## Response to City of Ryde

**Table 1 REVISED RESPONSE TO SUBMISSION (RRTS) January 2020**

Ivanhoe Estate - 2018/2019 Development Plan Changes

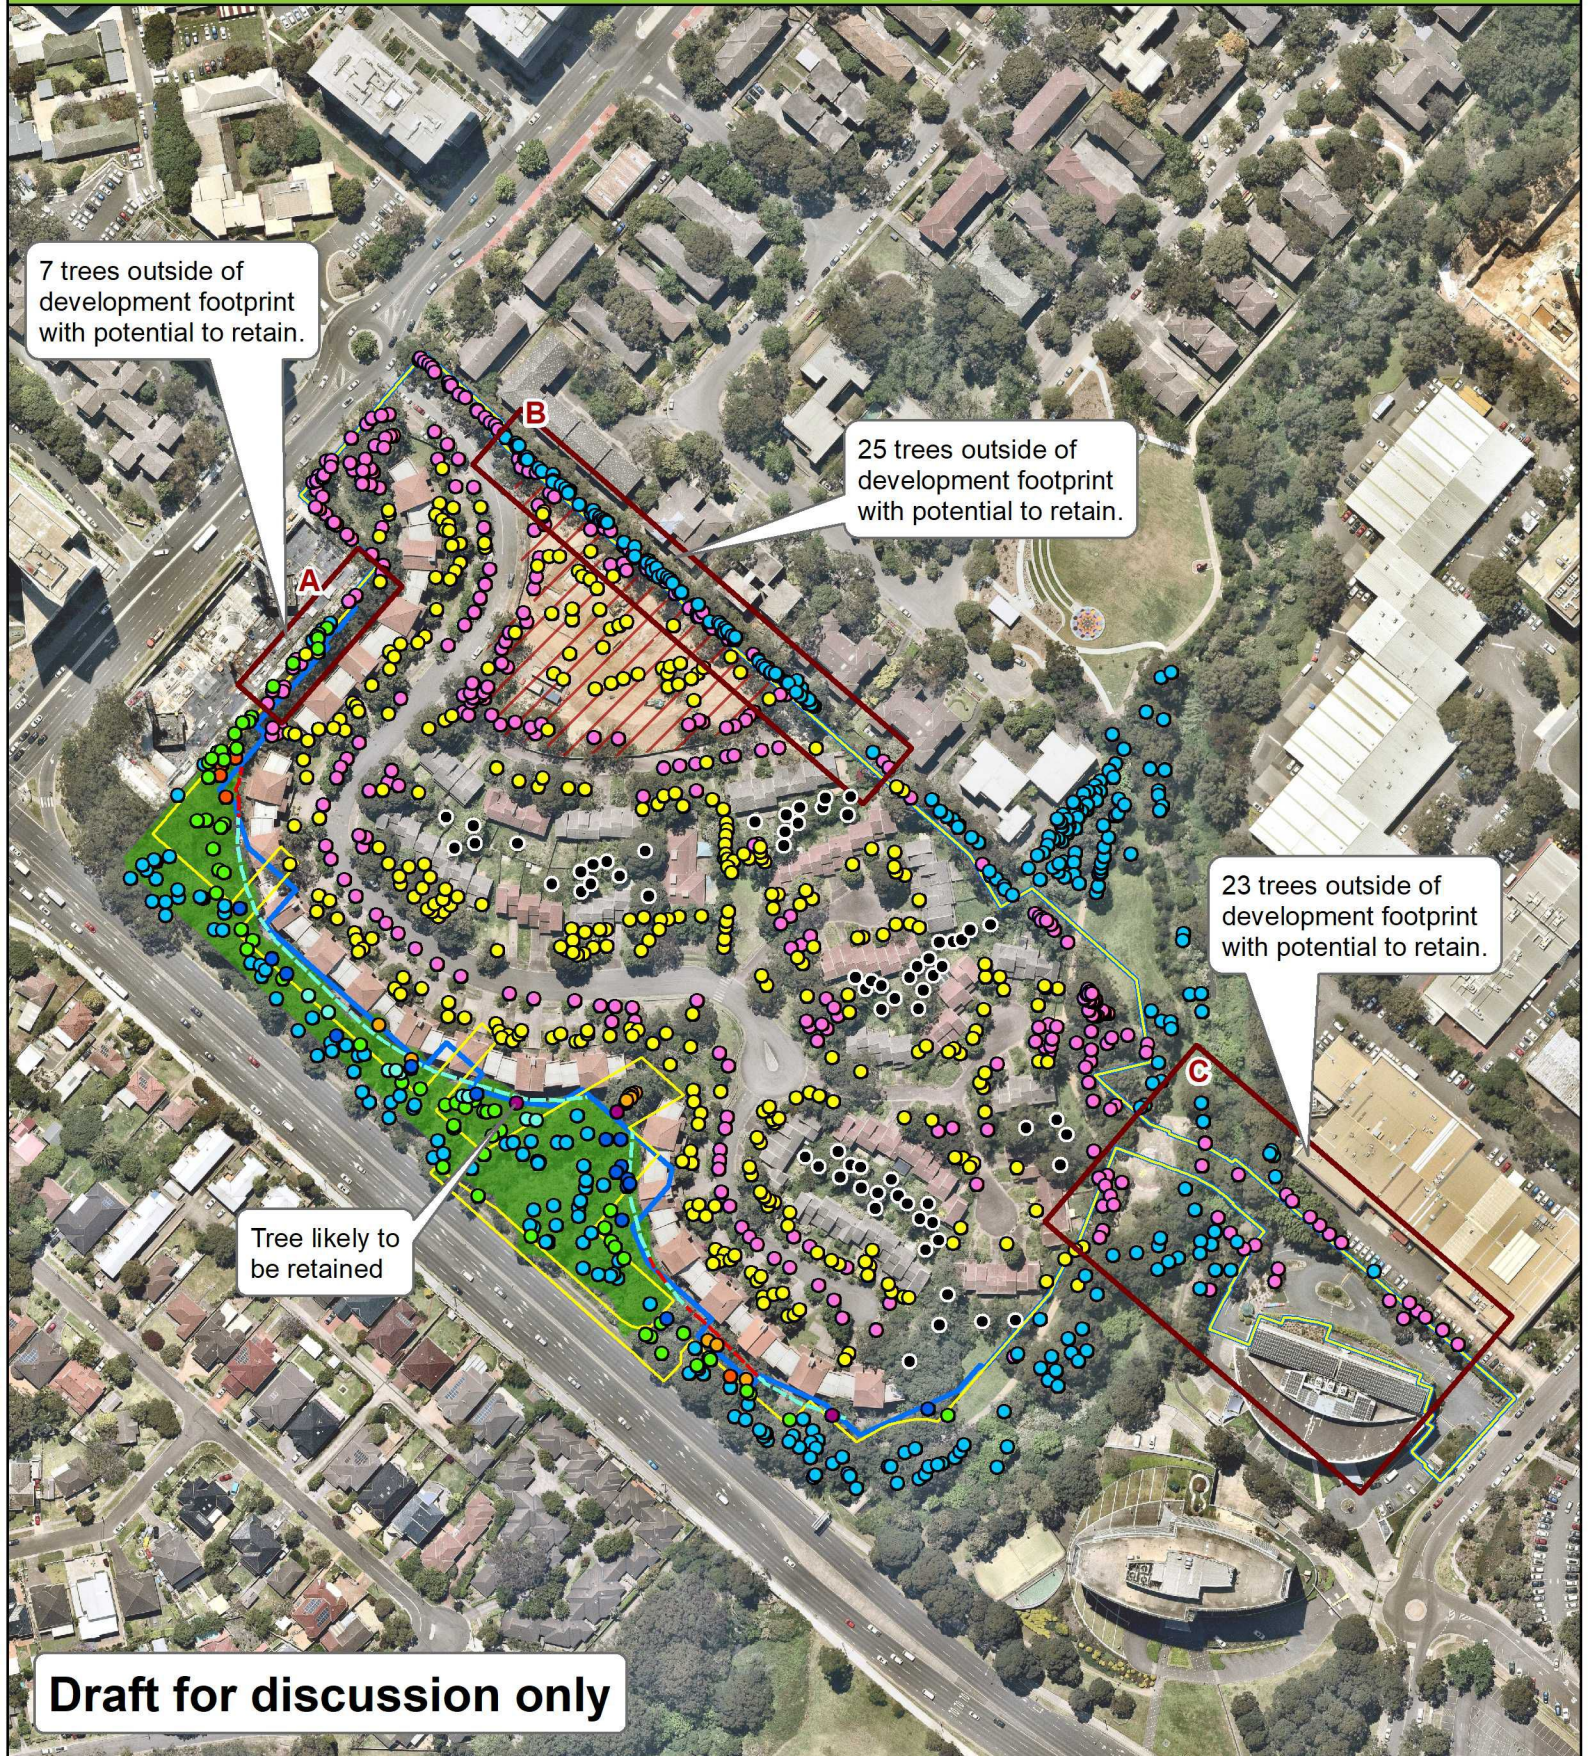
2	Existing retaining wall adjacent to EEC & along Epping Rd - Tree protection	<p>LAHC has indicated that the retaining wall that retains the raised land that supports the existing trees (along Epping Rd boundary) will not be removed. The Concept Plan seems to also indicate that the retaining wall and the bunkers will not be removed. However, details are not clear as to how this will be achieved.</p> <ul style="list-style-type: none"> <li>None of the plans show clarity on how this can be achieved;</li> <li>Whether the bunkers engaged to the retaining wall will be removed;</li> <li>What happened to the trees crowns that are immediately adjacent to the retaining wall;</li> <li>Arborists Report adds to further confusions where it states "retention of the existing retaining wall (and ancillary existing structures) where possible".</li> </ul>	<p>While the Concept Plan seems to show that the setback along Epping Rd will be increased to protect the trees, Part 5 Approval (Activity Determination) issued by the Land and Housing Corporation for demolition and tree removal contradicts the revised Concept Plan. Council had separately raised issues with LAHC with respect to the validity of the Part 5 Approval. The LAHC has indicated that it will modify the Part 5 Approval to align with the Concept Approval. Refer to attached letter to City of Ryde from the LAHC (Appendix B).</p> <p>The revised Concept Proposal seems to vaguely imply that the retaining wall will be retained. The following details are not clear in the revised application:</p> <ul style="list-style-type: none"> <li>Application does not clearly indicate that the retaining wall will remain intact and shall not be removed. Page 2 of the Arboricultural Report states: "retention of the existing retaining wall (and ancillary existing structures) where possible". City of Ryde is of the view that this should not be open to discretion of contractors and retention of the retaining wall needs to be clearly stated on the plans and with any approval, to ensure no corridor disturbance occurs and requirement is clear for all parties.</li> <li>There is not enough details in the Concept Application to indicate infill plans for 'alcove' bunker areas as discussed on site by Frasers along Epping road post build. If bunker is removed during demolition, what is the plan to reinstate the wall of structural integrity of the retaining wall.</li> <li>Tree species may likely to be impacted within the crown zone along the retaining wall when demolition or construction works occur. However, none of these trees have been individually assessed and nominated within this document. The assessment</li> </ul>	<p>The demolition of all existing dwellings and associated structures forms part of a separate approval process. With respect to retaining walls, Drawing No. DA01.MP001[6] details the number of retaining walls and associated structures for removal by others. It is prudent to note that the retaining walls are non-engineered, timber sleeper walls at the base of earth batters (refer to the photos included in the BAS). The reference to "where possible" must remain to ensure retaining walls / earth batters can be made safe and rectified in order to protect the EEC as necessary.</p> <p>a) In accordance with Figure 3 of the AIA report, four trees are proposed for removal from the EEC. Three trees are proposed to be removed during demolition (not part of this consent) which relate to tree numbers 1170, 1172 and 112. One tree is impacted as a result of construction which relates to tree number 9951. These exact trees are shown to be removed on drawing DA01.MP.001[6] No other trees that are proposed for removal form part of the ECC community.</p> <p>b) Where possible, retaining walls will be retained to minimise impact on trees and the EEC community.</p> <p>c) Where possible, retaining walls will be retained to minimise impact on trees and the</p>
